**From:** Planning  
**Sent:** 26 July 2021 14:29  
**To:** Planning  
**Subject:** R&U Planning Application Comments - 3/2021/0661

**Planning Application Reference Number:** 3/2021/0661

**Your Comments:** Whilst I accept that this project needs to proceed to ensure future water suppliers, I strongly object to the proposal to route heavy traffic through Chatburn, Grindleton and West Bradford, when a viable alternative has been suggested.

UNITED UTILITIES WATER LIMITED
 HAWESWATER AQUEDUCT RESILIENCE PROGRAMME
 RIBBLE VALLEY BOROUGH COUNCIL (MARL HILL)
 HIGHWAYS WORKS PROPOSALS - TYPICAL ROAD WIDENING
 CROSS SECTIONS - SHEET 12 of 12

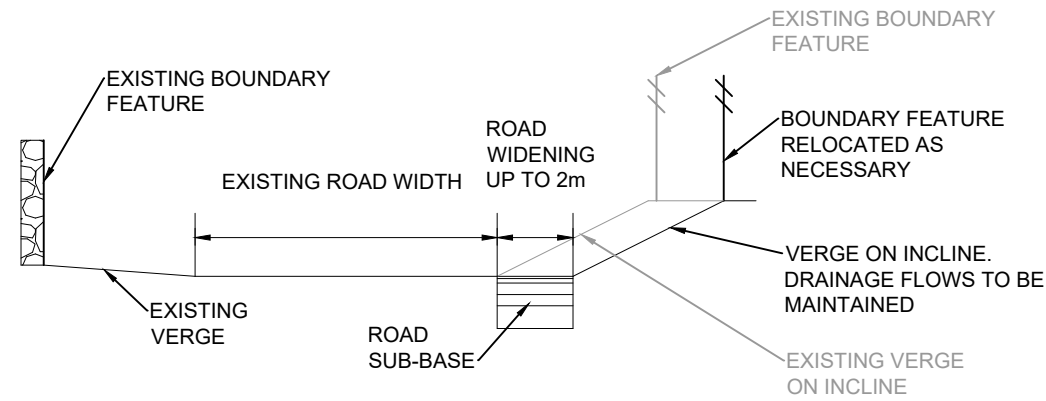
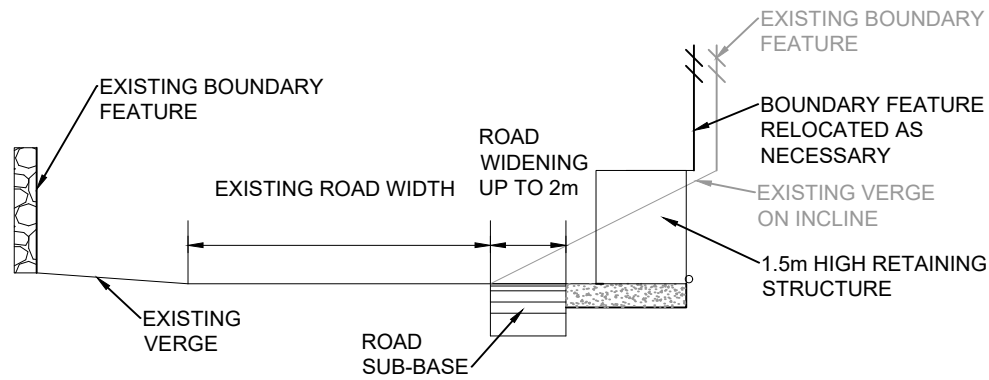
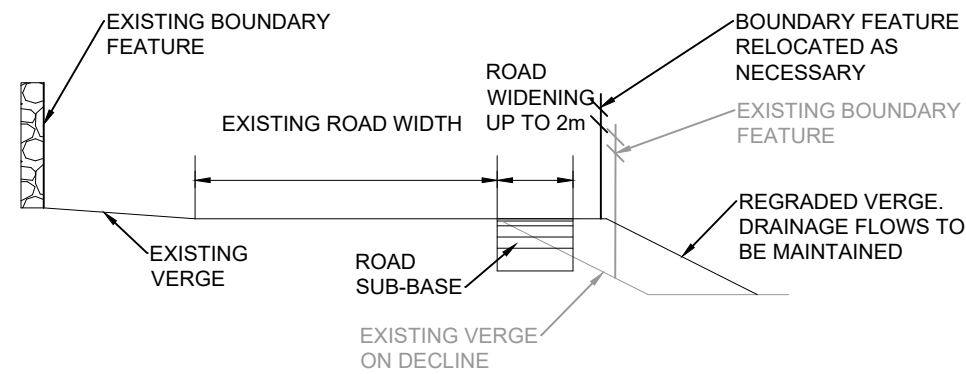
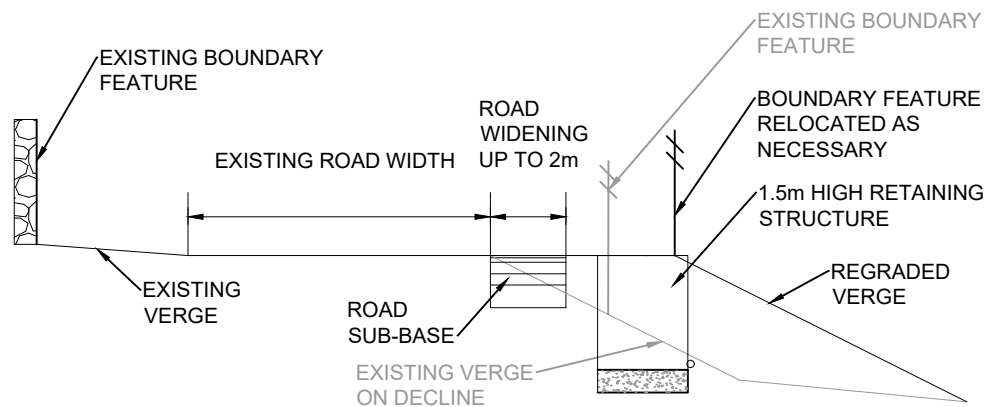
Road Widening, the plans show widening before and after Grindleton bridge to allow vehicles to get enough angle to cross, if the original route is not fully re-instated afterwards this will then become a regular crossing for heavy vehicles.
